Appeal Decisions

Appeal A Ref: APP/N5090/W/21/3279107

Pavement outside 47 The Broadway, Mill Hill, London, NW7 3DA

Appeal B Ref: APP/N5090/Z/21/3279108

**PART 1 - SITE PLAN AND IMAGES**

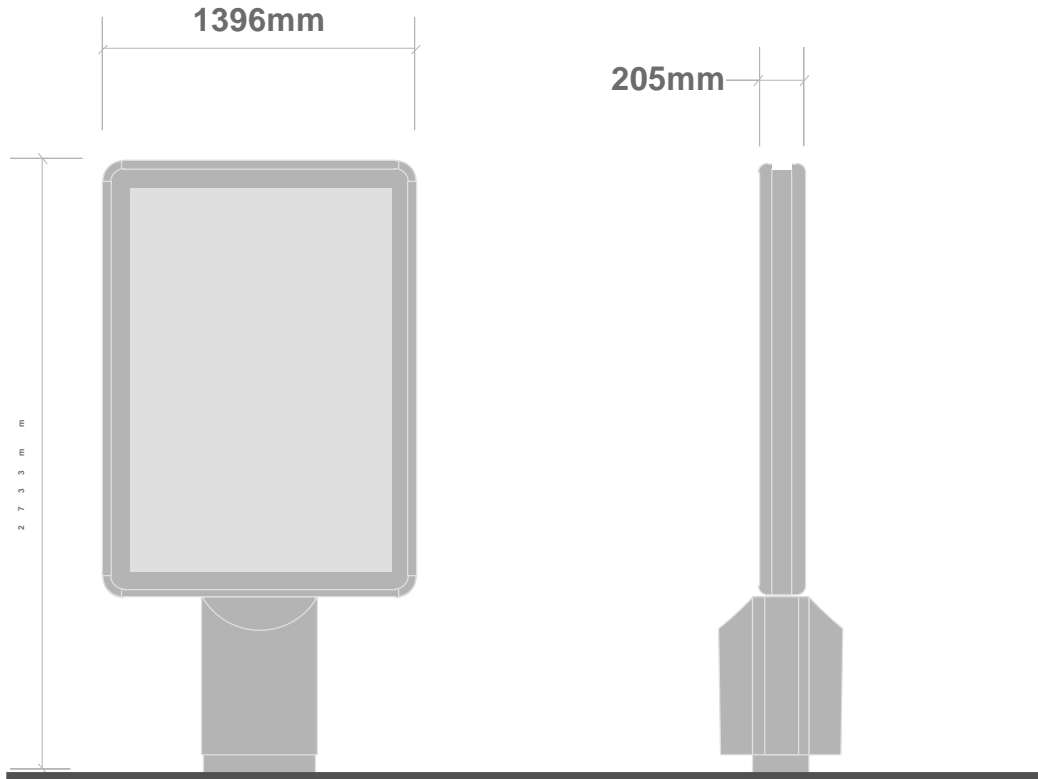
8. The proposed communication hub would replace an existing double sided advertising unit. This existing unit is of a similar height above ground as the appeal proposal and is slightly wider. The proposed communication hub would be in a similar position as the existing unit, but would be sited perpendicular to the adjacent road, rather than at an angle to it. As a result of this siting, it would also protrude further into the pavement between the highway and the retail units.

15. Furthermore, the proposed communication hub would protrude further into the pavement than the existing unit, which is broadly in line with a street tree and is at an angle to the pavement. Whilst a distance of about 4.8m would be retained between the proposed development and the frontage of the commercial units, the communication hub would not be well aligned with most of the other street furniture and accordingly, could obstruct the path of pedestrians or users of the pavement with disabilities or visual impairments.

Unit Elevations

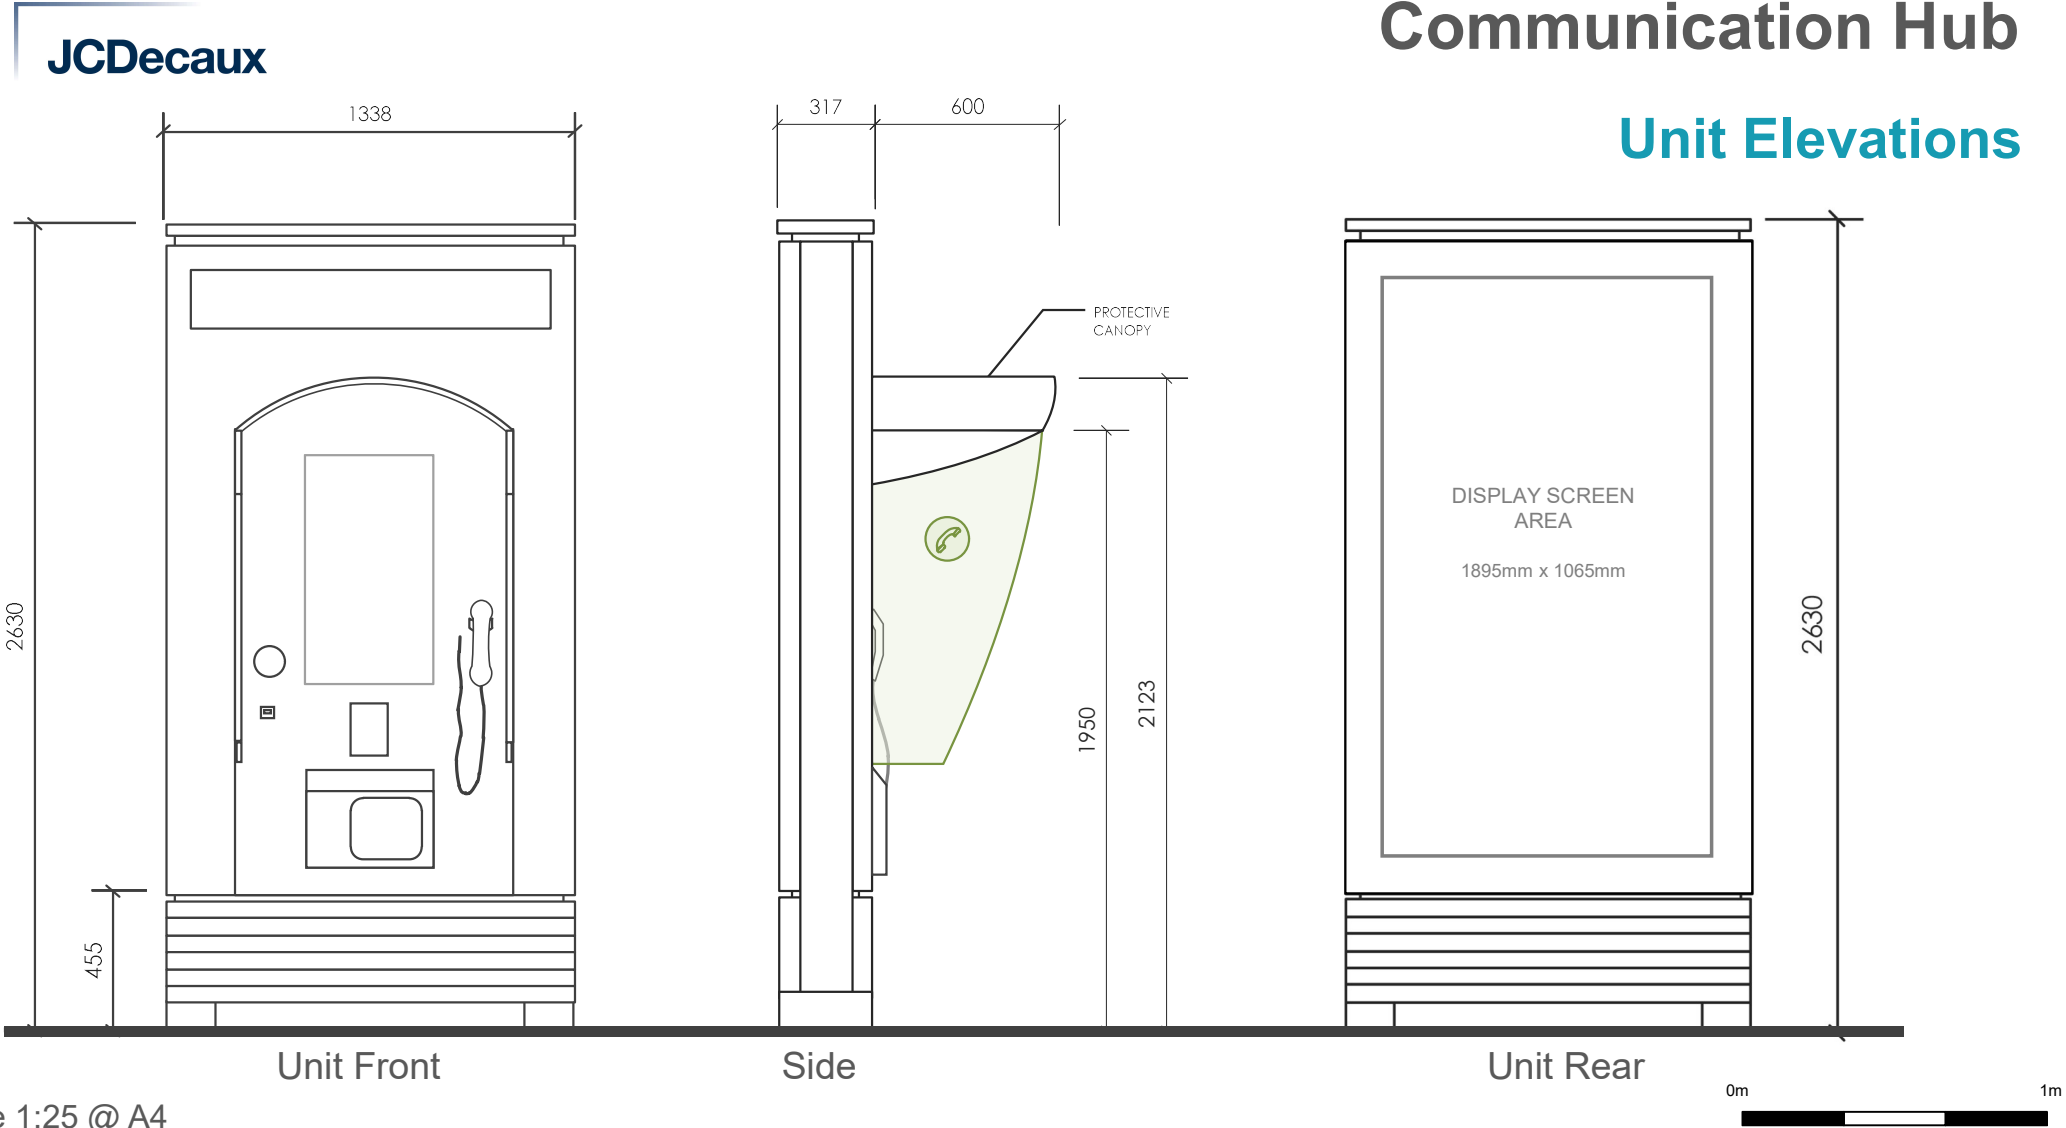
7. The proposed communication hub would have a height of 2630mm and a width of 1338mm. It would have a depth of 317mm plus a projecting canopy of 600mm.

13. The proposed advertisement would face oncoming traffic travelling in a north easterly direction. Even though the advertisement / information images are static, they are designed to change display at regular intervals which, in my view, would have considerable potential to distract drivers and other road users.
